Agenda Item: Construction Traffic and Access

From [REDACTED], Gt Staughton Parish Council [REDACTED]

Drawing Title
Indicative Construction Access and Compounds
Sheet 2 of 5

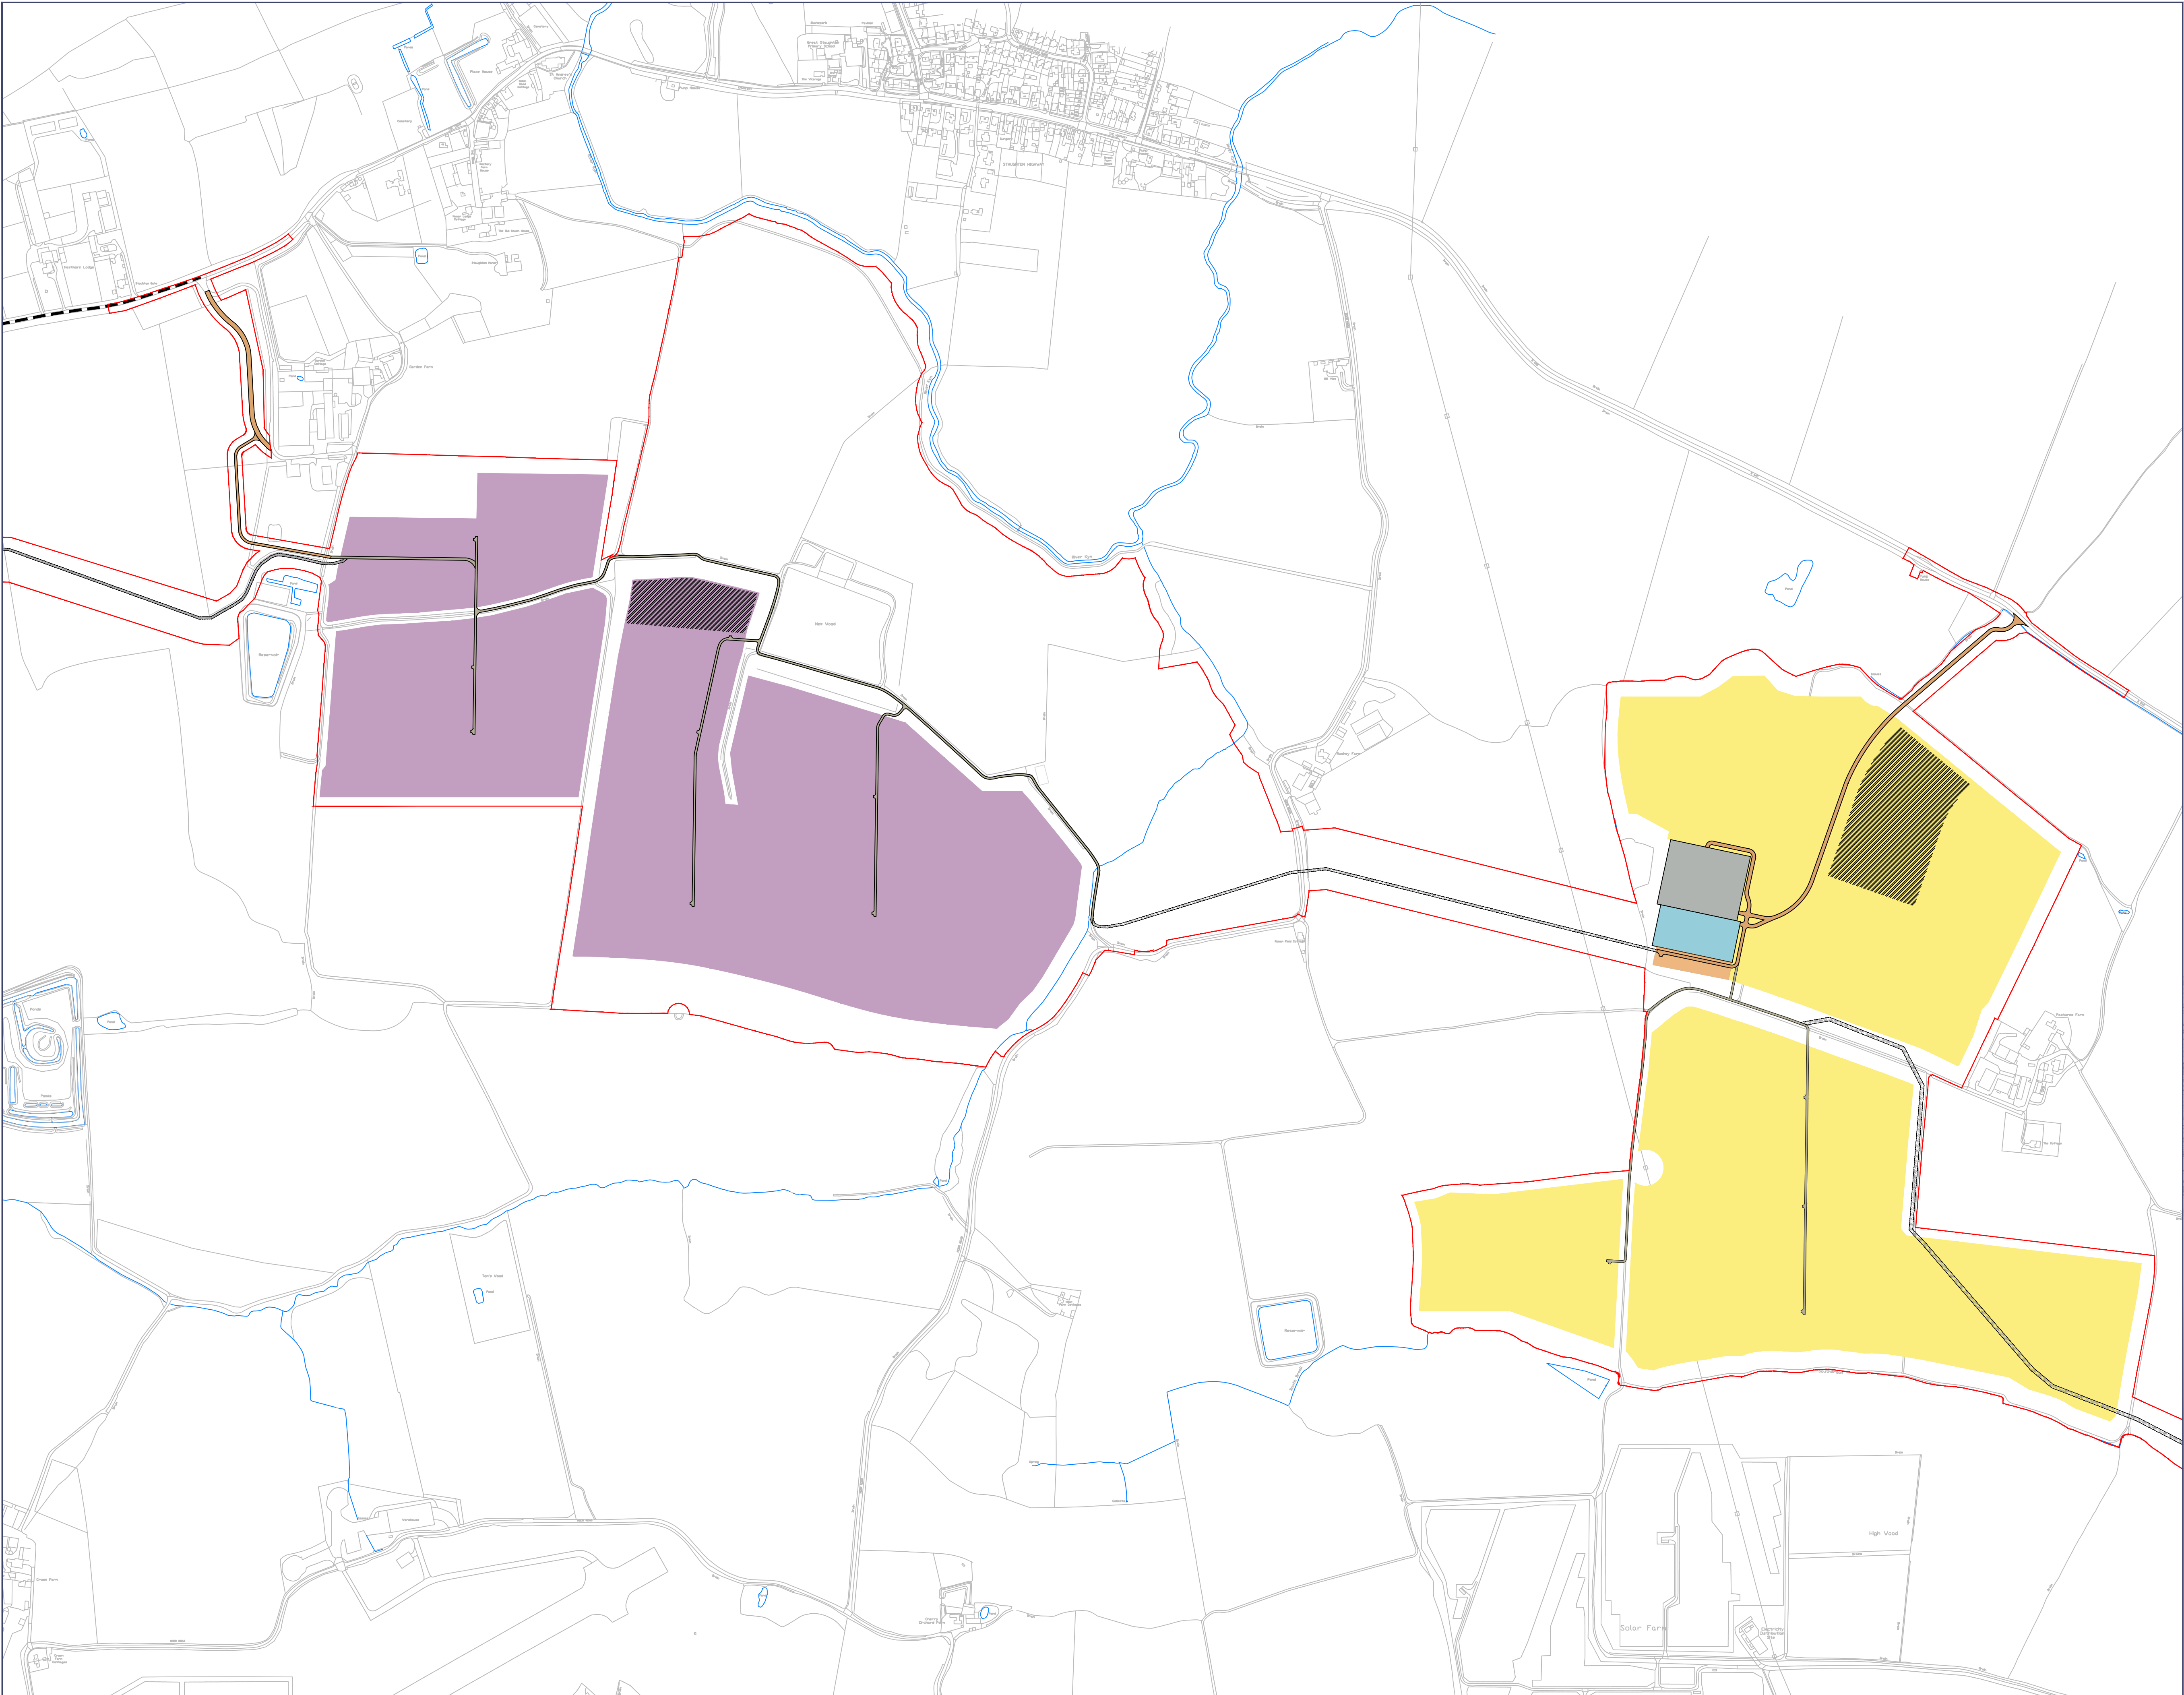
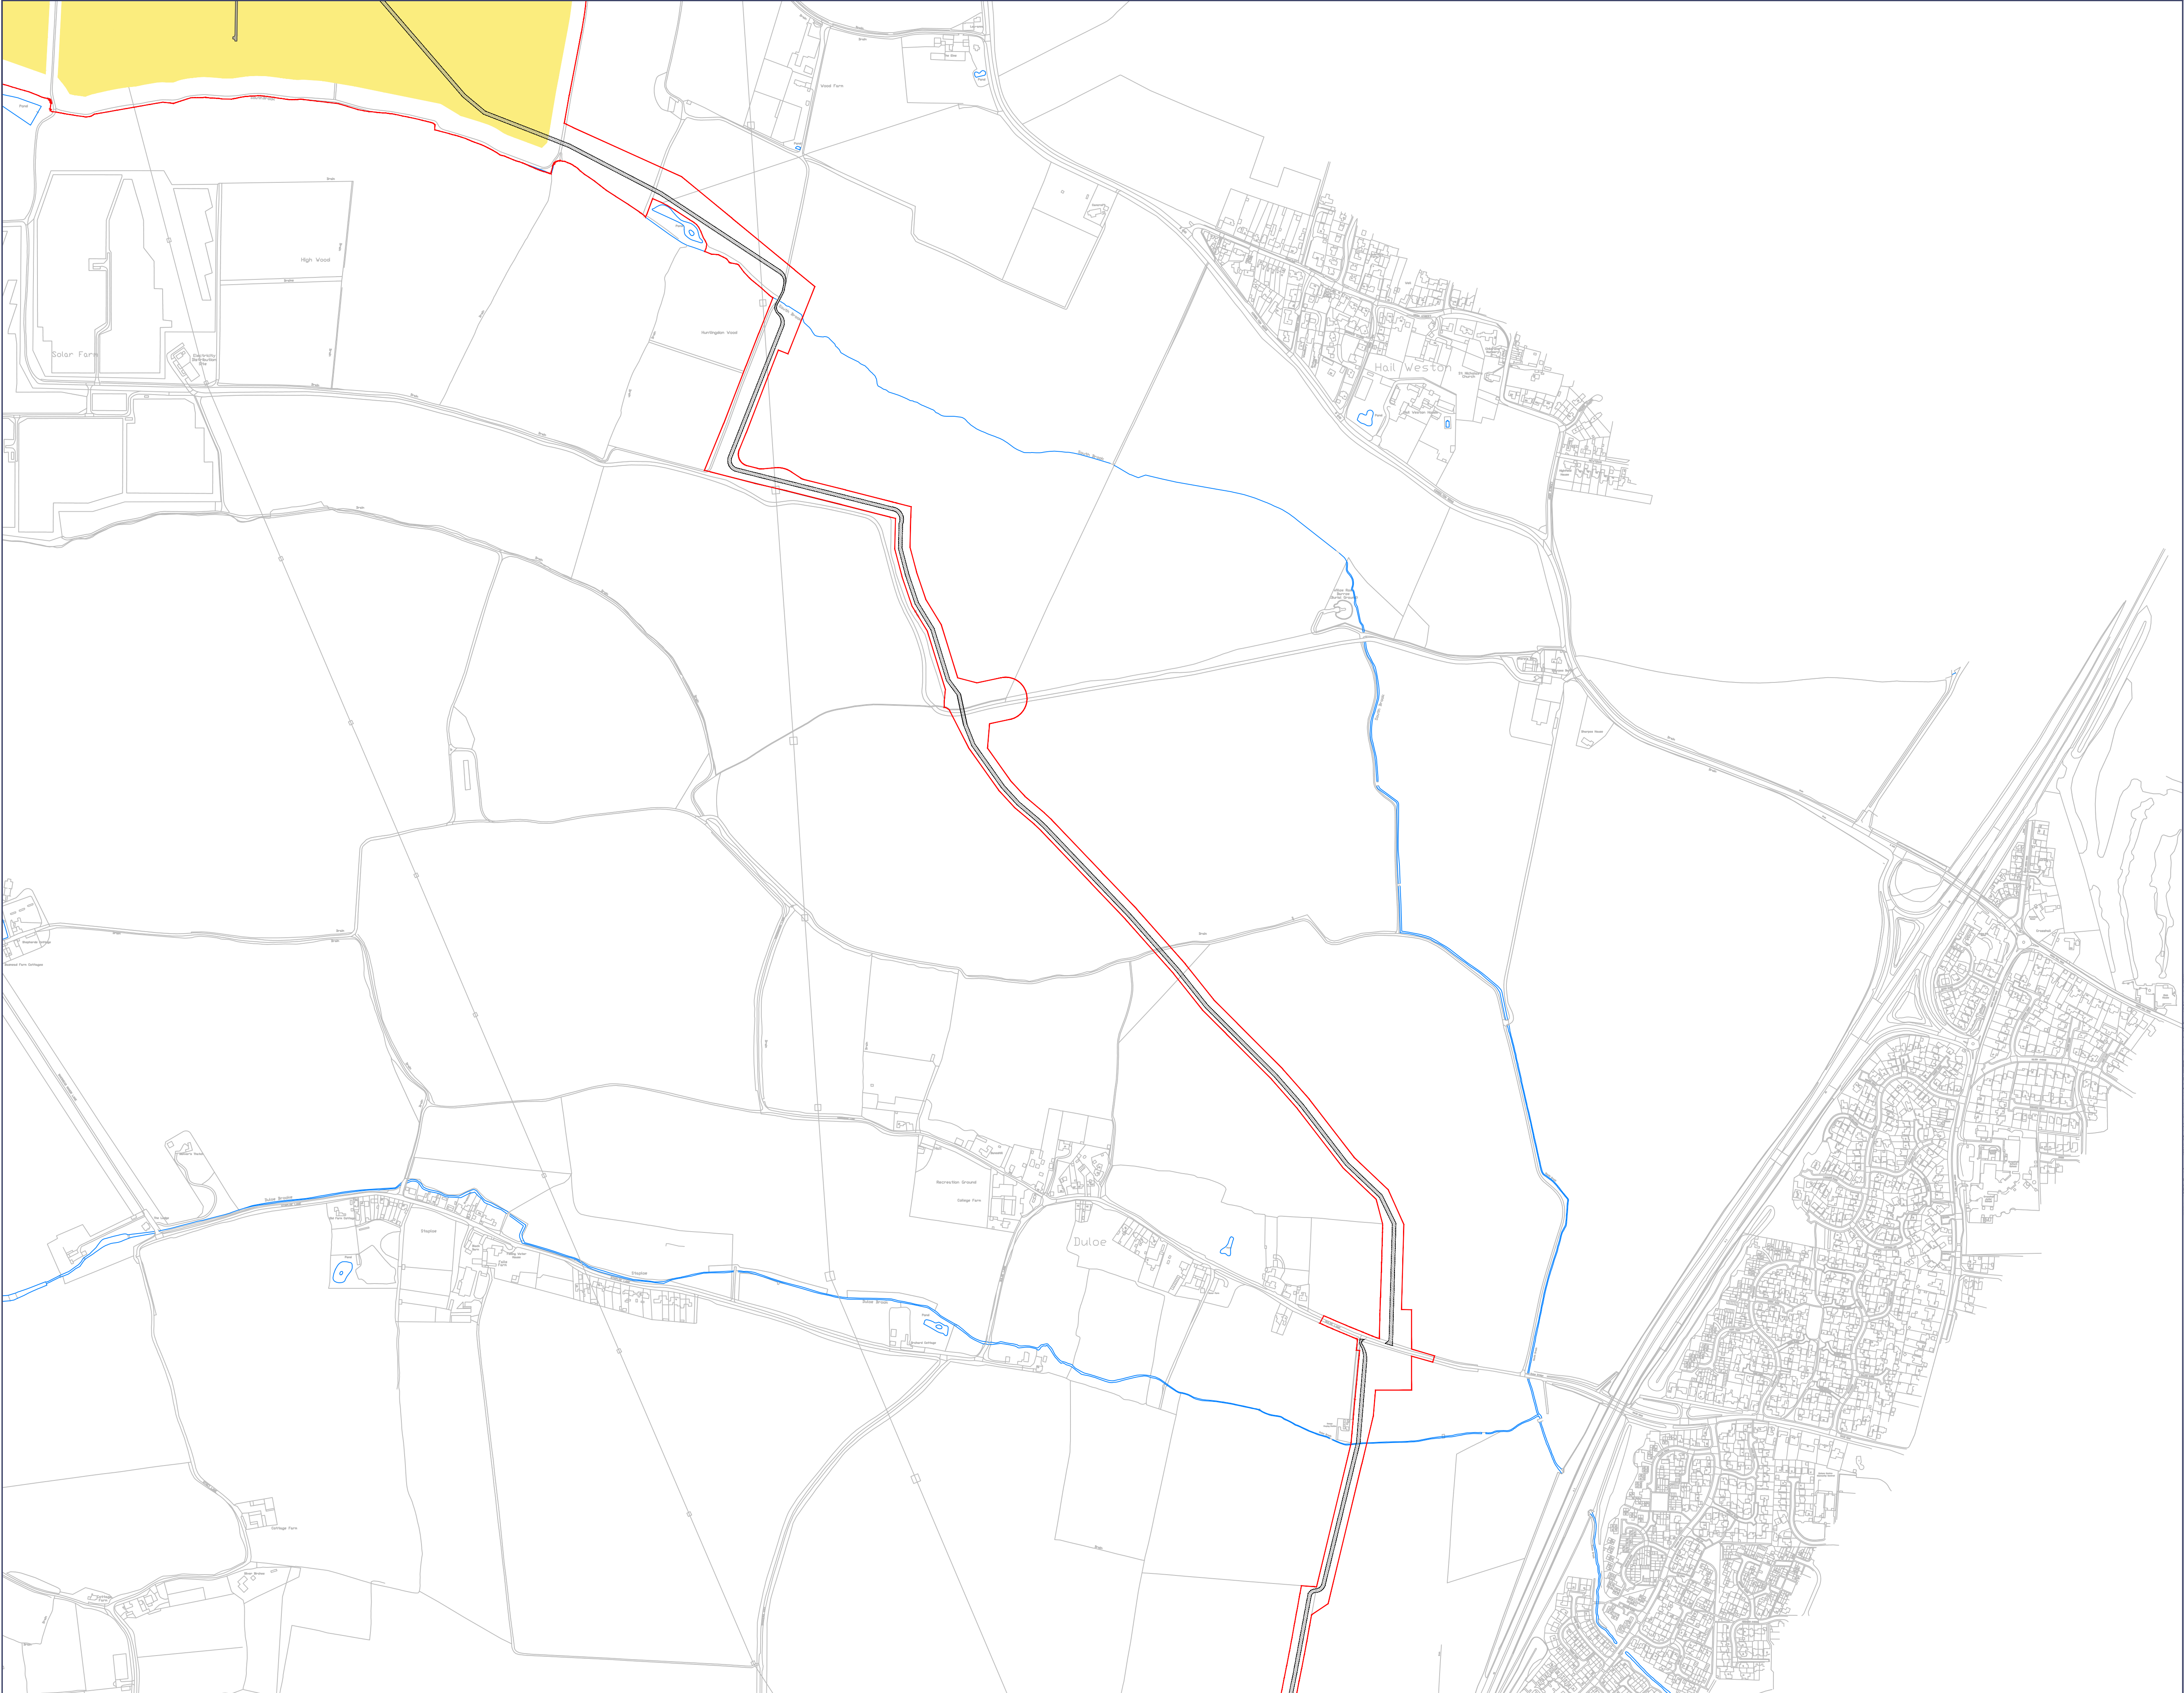
We understand that Brockwell's intention is for all the site traffic to come from the A1 along the B645 and enter the point at SA16. However, we would like to see a commitment that this will be strictly enforced otherwise we suspect that construction traffic including HGVs will be tempted to take the shortcut from SA12 back through the village in a way that would be exceedingly dangerous and disruptive:

B645 (MAIN ACCESS SA16 to site D). This stretch of road is considered locally to be extremely dangerous:

Gt Staughton Road towards Pertenhall, around SA12 and the Zantra site

This minor road is not suitable for HGVs, being barely more than 5m of tarmac wide in some places, with two passing HGVs requiring **5.7m** of width to clear their mirrors safely. Also the use of this stretch of road will make it very tempting, without very

strict enforcement, for construction traffic to take shortcuts through the village. It would be better if this stretch of road was not used at all for construction traffic.

We are concerned that the project will cause obstruction on the B645 (especially around the main site D access SA16) which is the route to and from work school and shops for many parish residents. Any blockages, hold-ups or temporary traffic signals will come at a significant economic and social cost to local residents.

We are concerned that the proposed access route appears to travel over the newly designated Roman Town Scheduled Monument, with cable trenching potentially under it. To avoid risk of damaging the monument, it would be better if the access route and cabling should be kept well away from the monument

2. **A Pre-Commencement Road Survey:** A legally binding 'Section 106' agreement for the developer to repair all road and verge degradation.
3. **A Physical Width Audit:** A requirement for the Applicant to prove, via 'Swept Path Analysis', how two HGVs can pass on Pigs' hill on the B645 and on Great Staughton Road without leaving the tarmac."

4. **Construction Traffic should not use the 'Gt Staughton Road'**, and instead should keep to a purpose built access track off the road network
5. **Construction Traffic and cabling should be kept well away from the scheduled monument.**
